**LOWER THAMES CROSSING**

**PROPOSED PUBLIC RIGHTS OF WAY**

**RESPONSE TO ExA ACTION POINT 9 ARISING FROM ISH10 TRAFFIC & TRANSPORTATION**

CLIENT: E AND K BENTON LIMITED  
 LTC ExA REF: AP1717  
 LTC APPLICATION DOCUMENT: REP2-073 9.6 Supplementary Walking, Cycling and Horse Riding (WCH) Maps (Volume B)

Plate 61

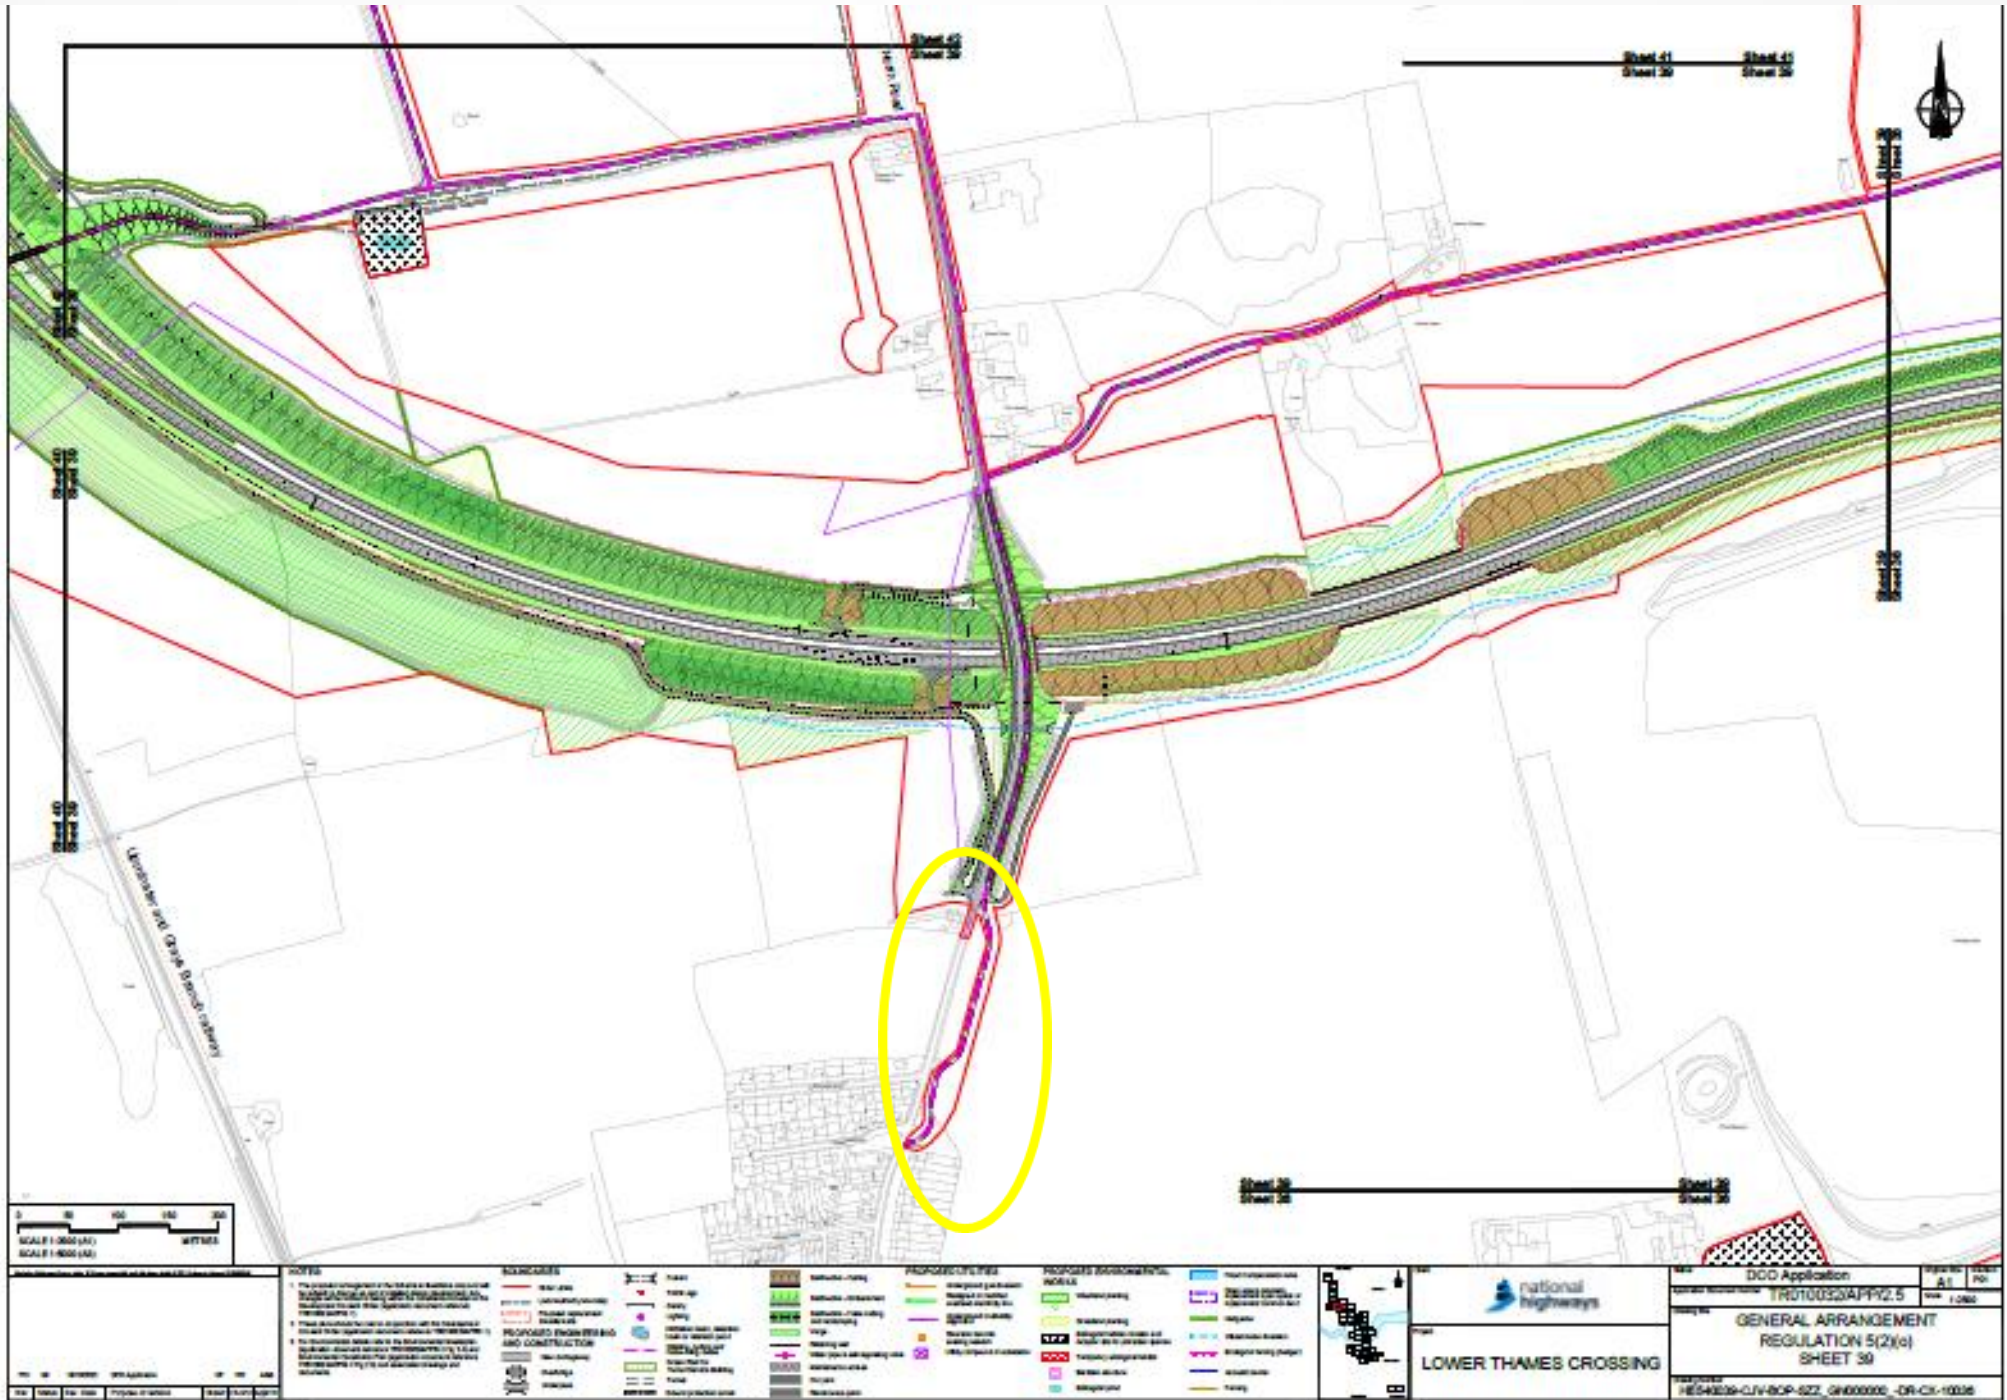
9. North Road WCH	new shared WCH route	Objection	Objection	Objection	Please refer to ISH10 oral submissions and D6 written representations on issues created by new PROWs/bridleway upgrades. We consider that the Applicant should review the opportunity to move the 30mph limit to the point marked 'A' on plate 61 of the CAH3 plates as submitted under the separate D6 written representations. The Applicant has previously cited the fact that this section of North Road being subject to a 40mph speed limit as being one of the reasons for the new section of WCH on our client's land to the east of North Road. We consider that a change in the speed limit zones will enable better use of the existing highway to satisfy access requirements without the need to acquire land and/or rights on our client's land. This stretch of road would then be of the same specification as the rest of North Road heading south into South Ockendon which is not subject to any additional WCH routes. There is an existing pavement in place along the west side of North Road, over 1.5 metres in width, which extends up to the foot of the proposed new North Rd bridge. Most users will be using the PROW to reach Thames Chase so it makes more sense to keep it to the west side.
